**RE: 5104 Kevin Court NW  
Grading and Drainage Plan  
Engineer's Stamp Date: 8/20/25  
Hydrology File: H11D077  
Case # HYDR-2025-00301**

Based upon the information provided in your submittal received 08/20/2025, the Grading and Drainage plan is **not approved** for Building Permit. The following comments need to be addressed for the approval of the above referenced project.

ENGINEER'S SEAL	5104 KEVIN COURT NW GRADING AND DRAINAGE PLAN	DRAWN BY DEM
		DATE 8-20-25
8/28/25	 RIO BOX 53204 ALBUQUERQUE, NM 87199 (505) 321-8099	SHEET # C1
DAVID SOULE P.E. #14522		JOB #

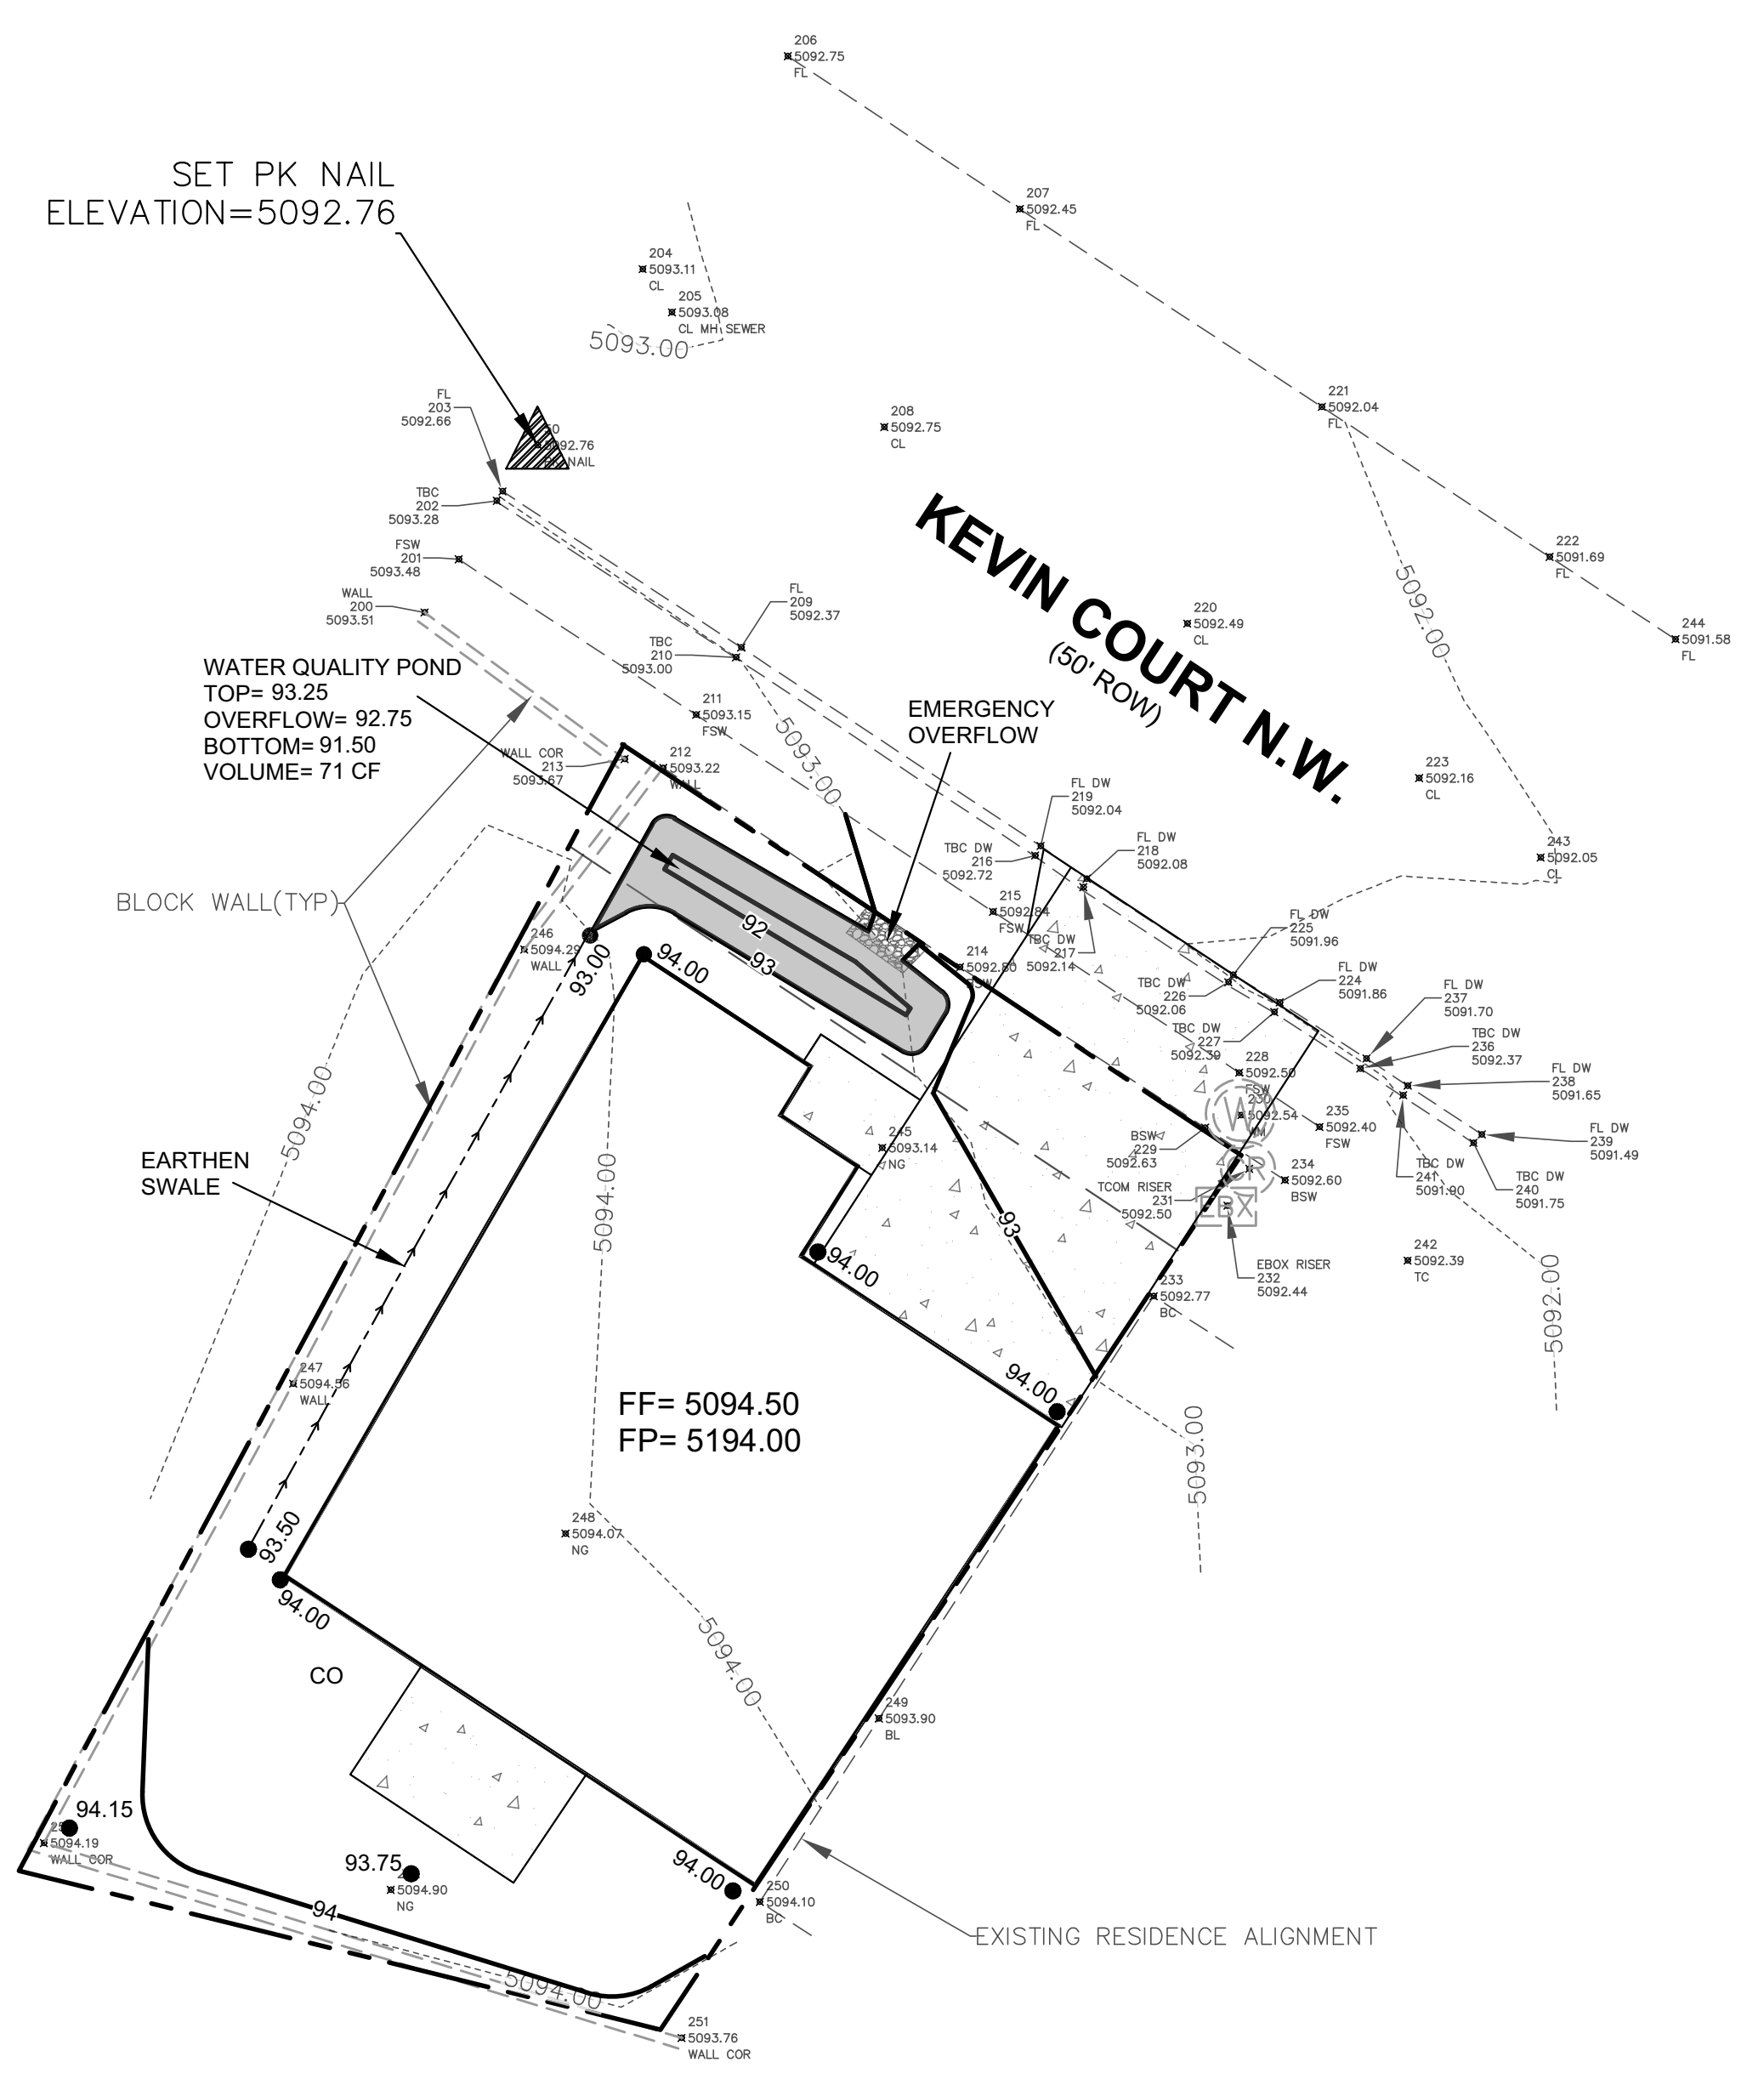
1. The Proposed Land Treatment percentages in the table exceed 100%.
2. Please show the Water Quality Volume calculation on the plan.
3. Please remove Note #6 requiring a Pad Certification.
4. Check the Legal Description. County records show it as: 1 REDIVISION OF TRACT B BLK 5 VISTA MAGNIFICA
